Harnett County Government Complex
307 W. Cornelius Harnett Boulevard
Lillington, NC 27546

Re: Status of Improvement Permit Application #13-5-30849 & #13-5-30896

James E. Manhart, III, R.E.H.S.
Environmental Health OSWW Specialist
Harnett County Department of Public Health

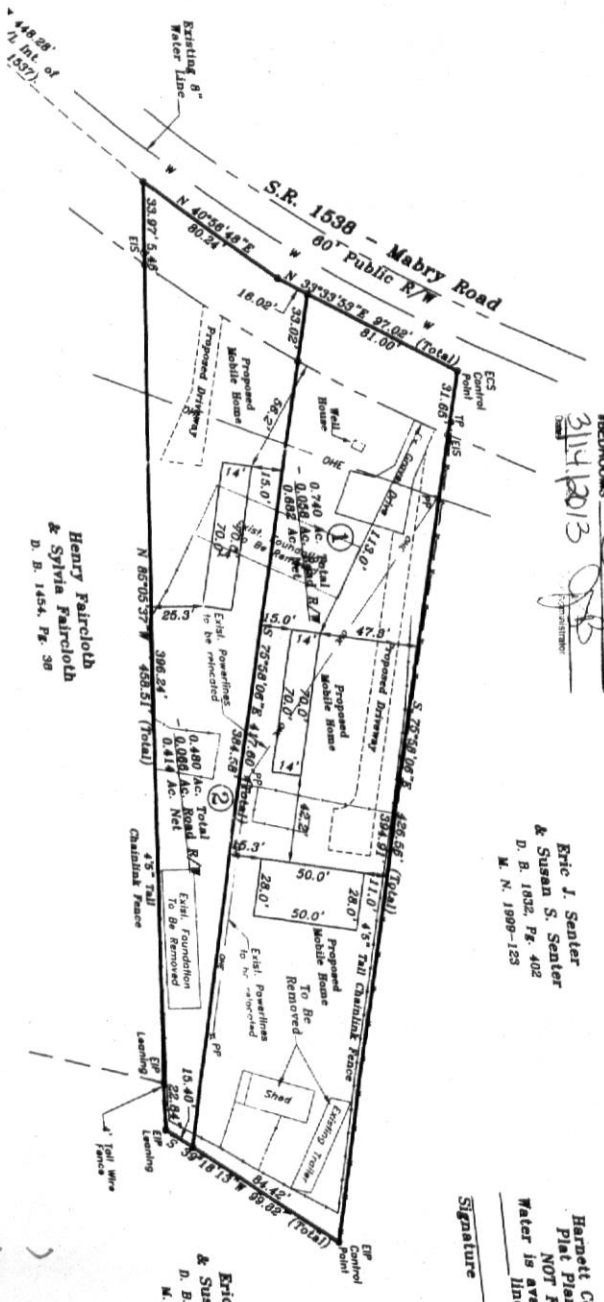
5. Driveway not shown on site plan

7. Other – On lot 1 all garbage must be properly disposed of behind MH. Septic tank must be uncovered and distribution box uncovered. (May need to locate drain lines) The 90 ft. easement must be marked.

Both applications refer to proposed septic tanks as being on lot 2 although site plan show 2 lots (1 and 2). Call me between 8-9 a.m. to discuss these items mentioned.
